Subject: RE: A/82/18/DOC - Quiet Water, Angmering - Condition 7 - SUDs

Hi Chris,

TYPICAL PRECAST SOAKAWAY
ARRANGEMENT
1:25 @ A3

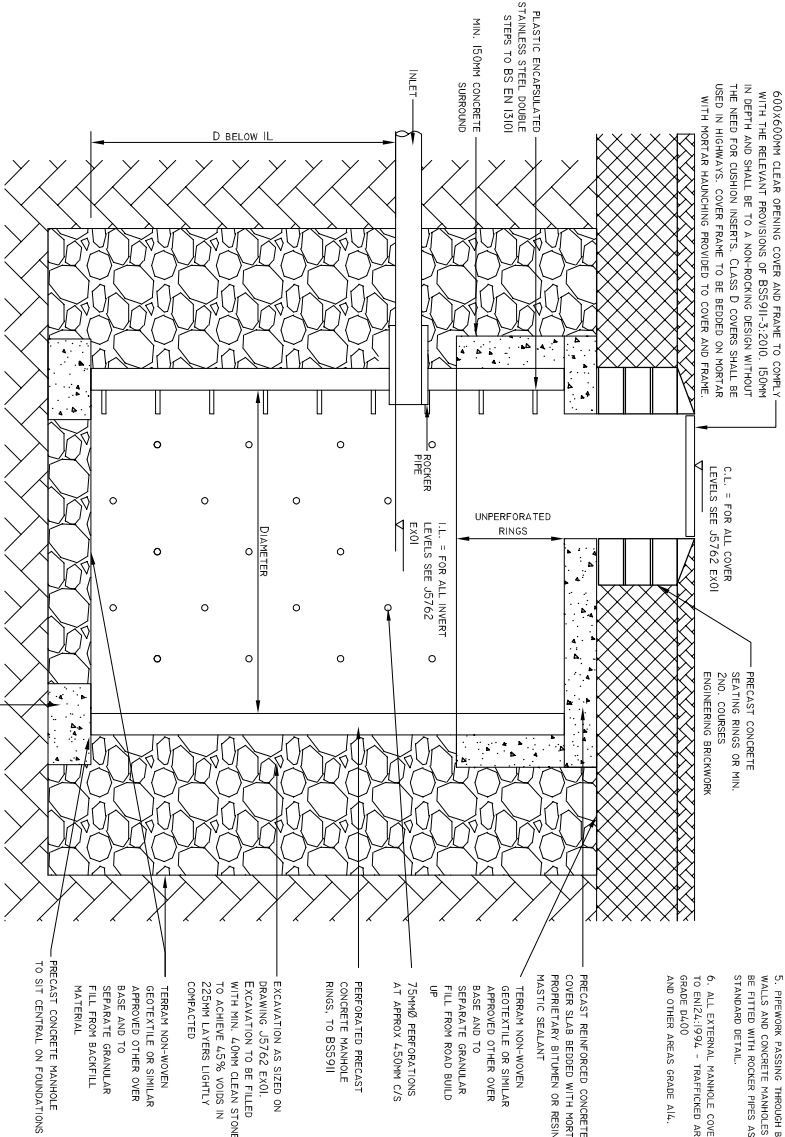
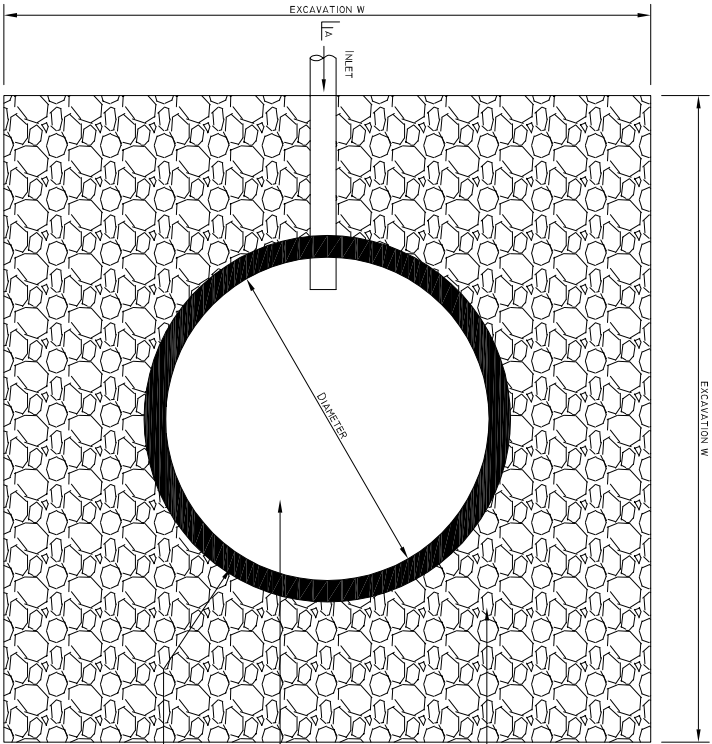
I have concerns regarding the efficacy of the design. There is little evidence based research regarding EGRP that proves that the system works for such purposes and that the design life is sufficient for the development. I have also been in conversation with Simon Deacon at the Environment Agency regarding the proposals, he has the same concerns. He also has concerns over pollution control with the proposed design.

Also, the justification provided to date for using such a system is in my opinion insufficient. The proposed drainage scheme relies on the construction of 2m deep trenches, so to say trenches are not safe to construct and that you do not want to use them is puzzling. Trenches can be safely dug and secured during works with what I would have thought is very little effort compared to drilling 300 boreholes.

As I stated to your consultant, I would recommend you use far more traditional methods for drainage and use similar methods to those utilised on the neighbouring site.
